A57 Link Roads Scheme DCO Application

**Representation and response on behalf
of the Peak District National Park
Authority to the Examining Authority's
questions within the Report on the
Implication for European Sites FINAL
requested for Deadline 9**

**Produced by the Peak District National Park
Authority (April 2022)**

Application by Highways England for an Order Granting Development Consent for A57 Link Roads

Insert 7 Glossop AADT Flow 2040

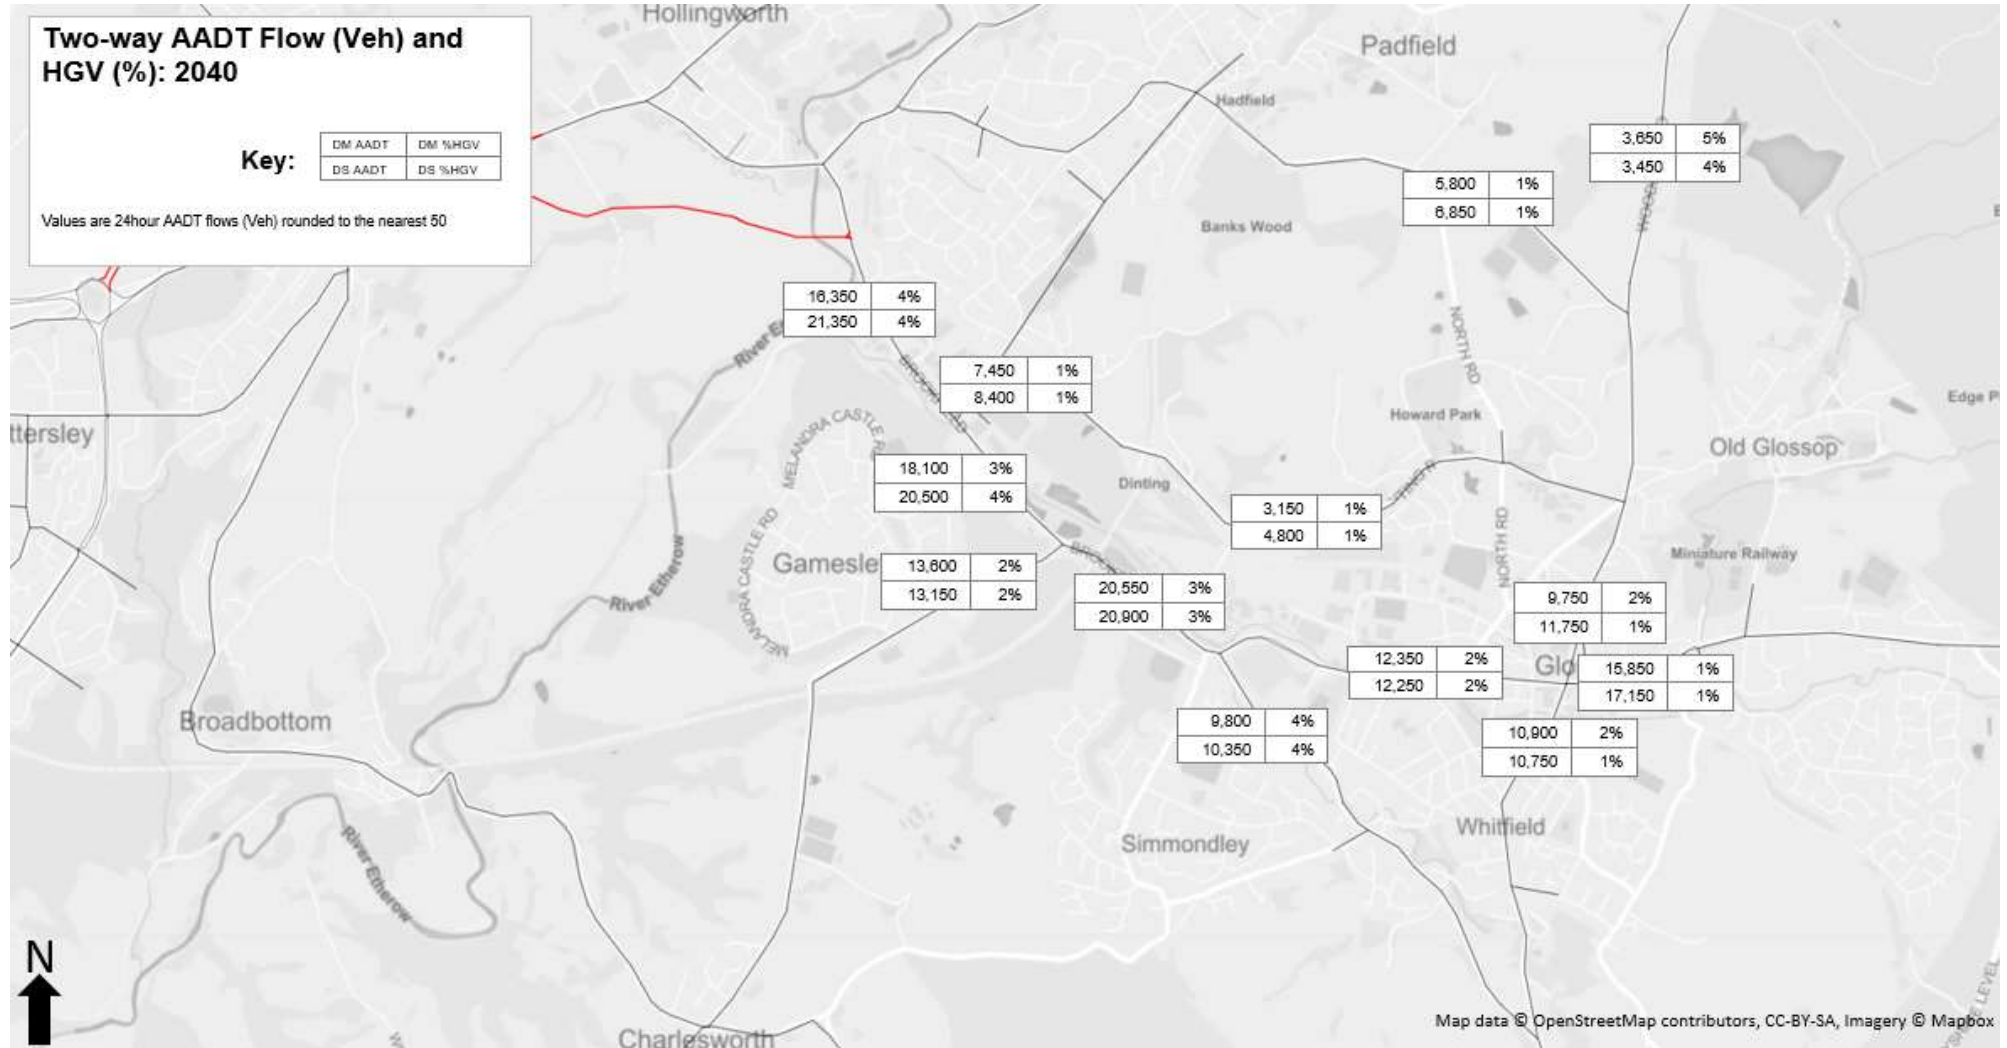
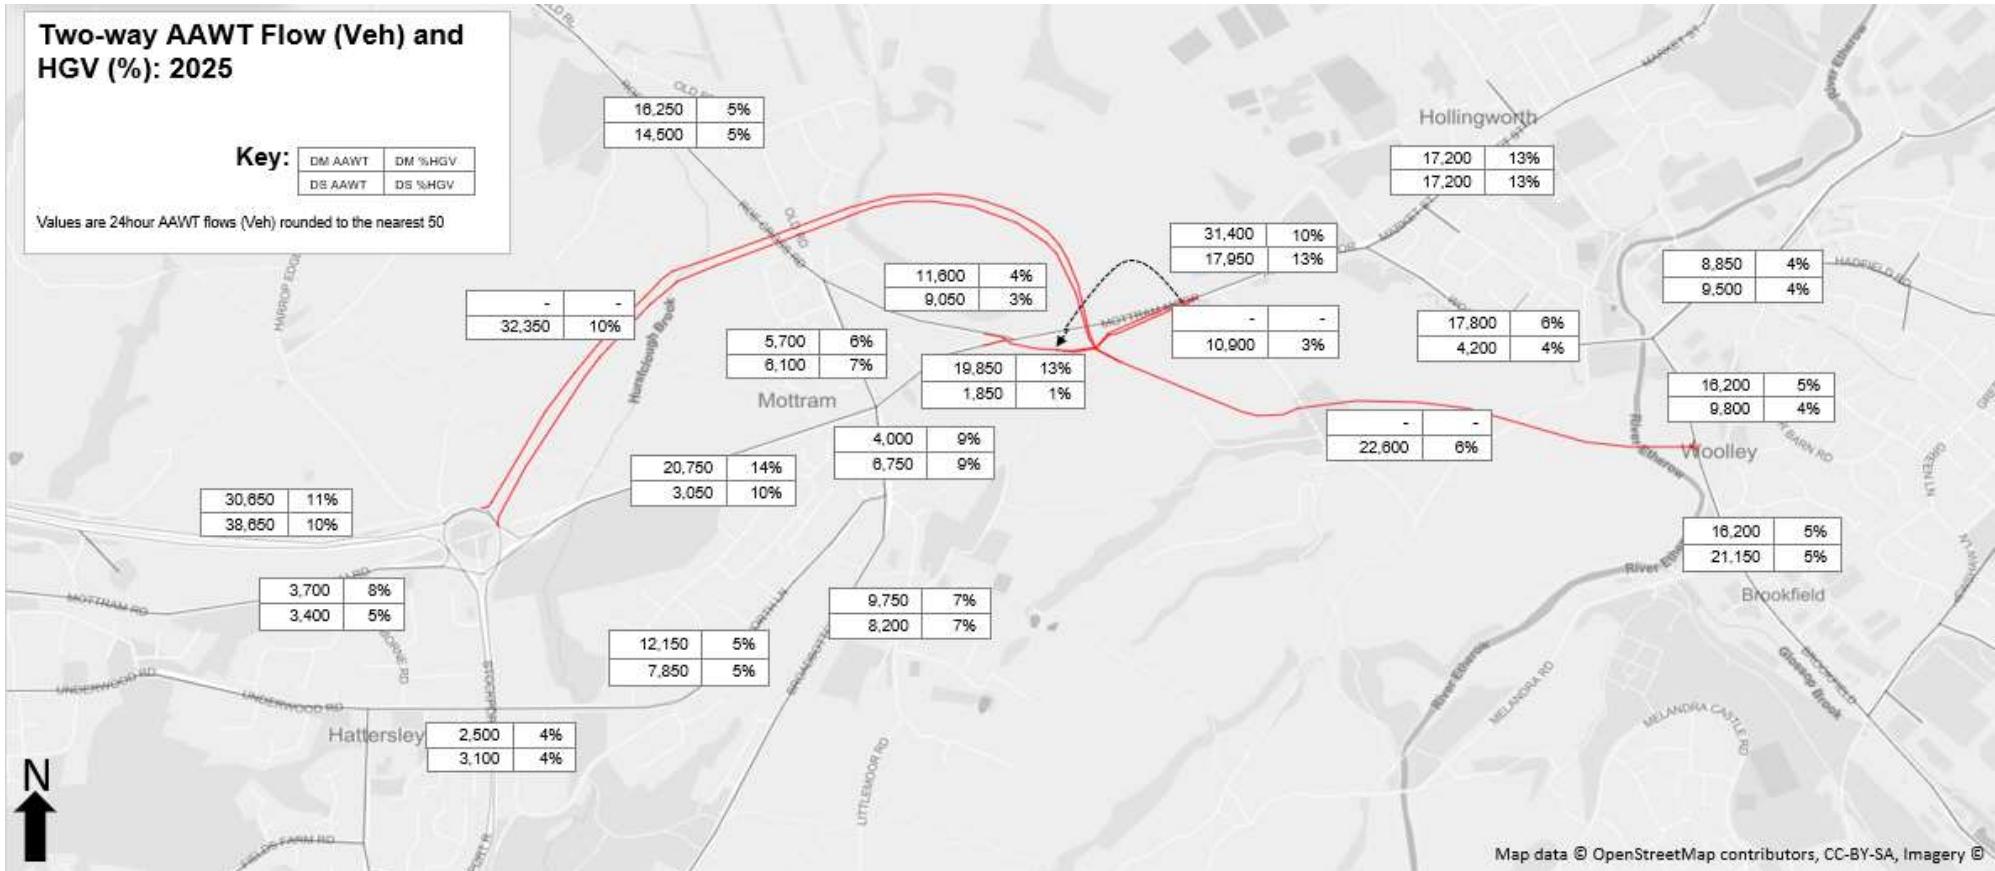
We re-iterate our concern that no statistical confidence levels for the predicted traffic flows appear to have been submitted, and it is therefore entirely possible that the predicted increases in traffic levels could exceed the AADT thresholds set out in the DMRB, and therefore require further assessment.
Peak District Moors (South Pennine Moors Phase 1) SPA	Issue- Habitat changes affecting availability of prey species	<p>ExA request- No specific request, but assumption that lack of comment from PDNPA means we do not consider there to be a likely significant effect from this pathway.</p> <p>PDNPA Response</p> <p>We confirm we do not consider a significant impact likely from this pathway.</p>
